LSC Responses to TIS Redline Comments

Homestead North Filing No. 3

Traffic Impact Study

PCD File No.: P-22-015 **SF-22-29** ¹

Figure 3

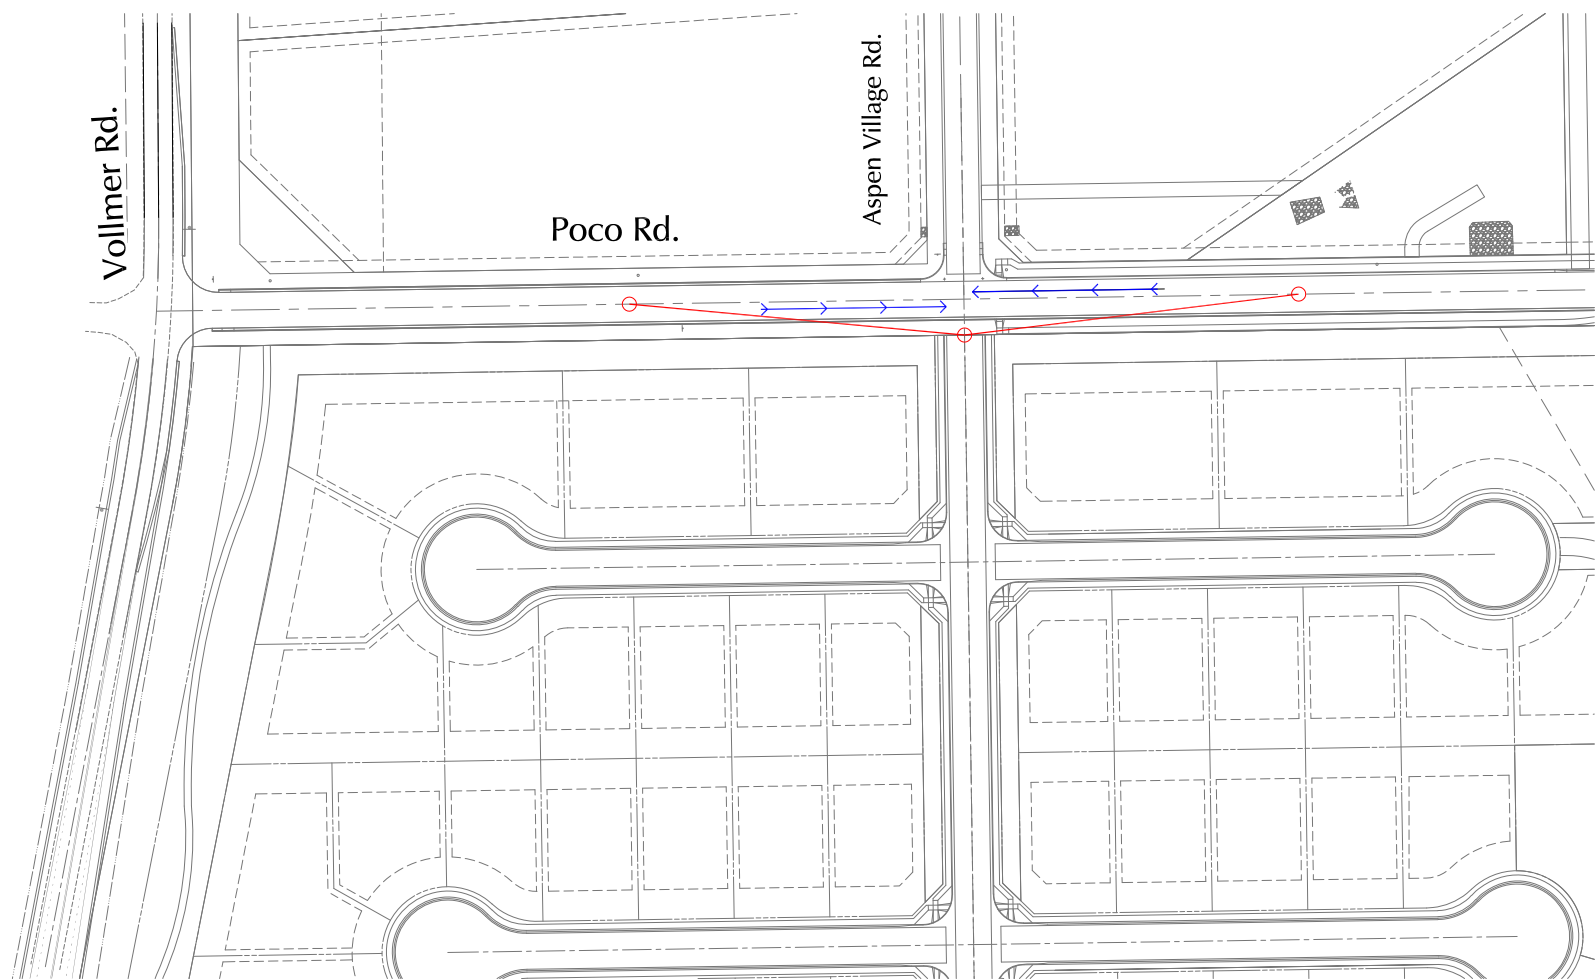
[Figure 4 shows existing traffic counts & LOS](#)

LSC Response: The text has been revised to refer Figure 3

Figure 8  
**Short-Term Site-Generated Traffic**

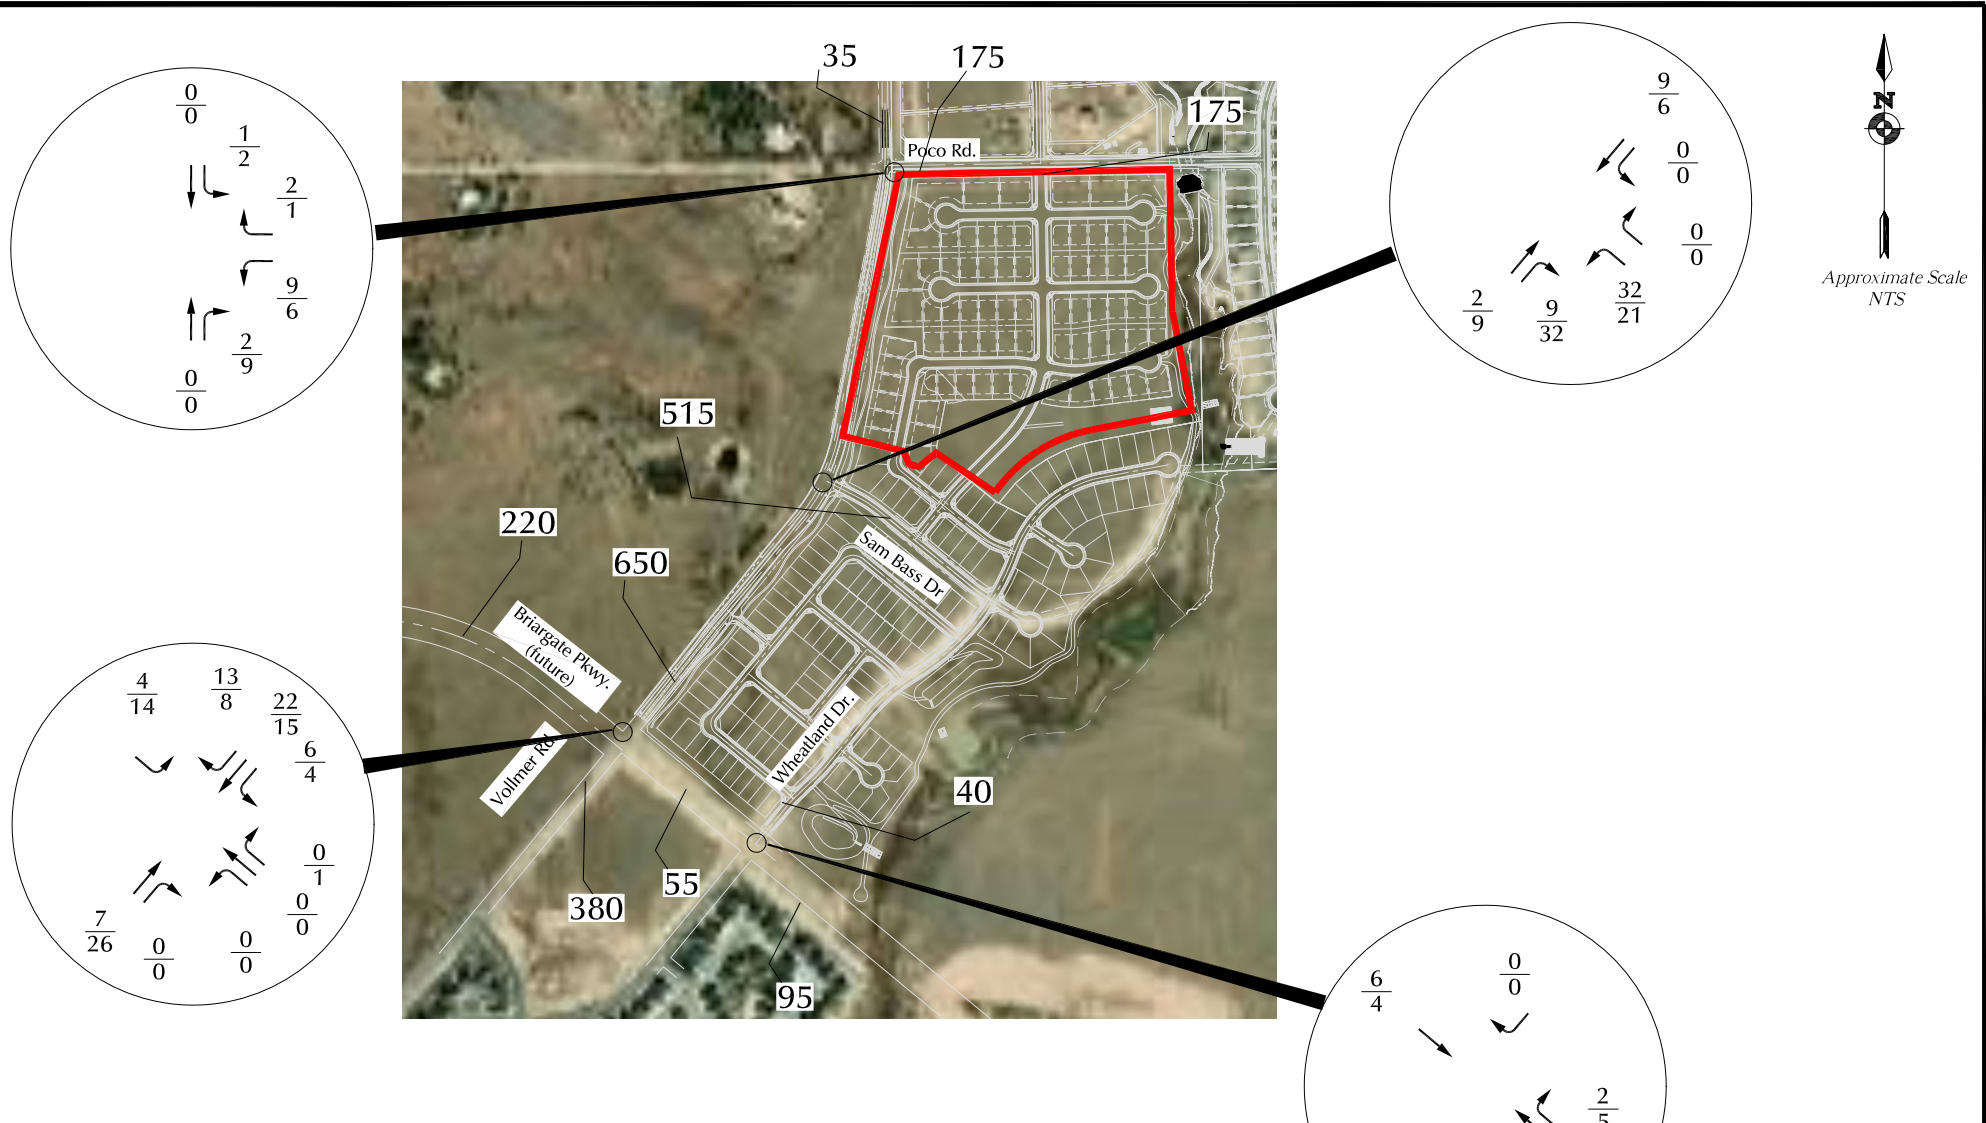
[Looks like part of paragraph may be missing based on previous version of report.](#)

LSC Response: The text below was removed because Briargate Parkway is now planned to be constructed to its final cross section in the short-term future.

"The short-term site-generated traffic volumes assume the intersection of Briargate/Wheatland as an interim full-movement intersection. The long-term site-generated traffic volumes assume the north leg of this intersection has been restricted to right-in/right-out only."
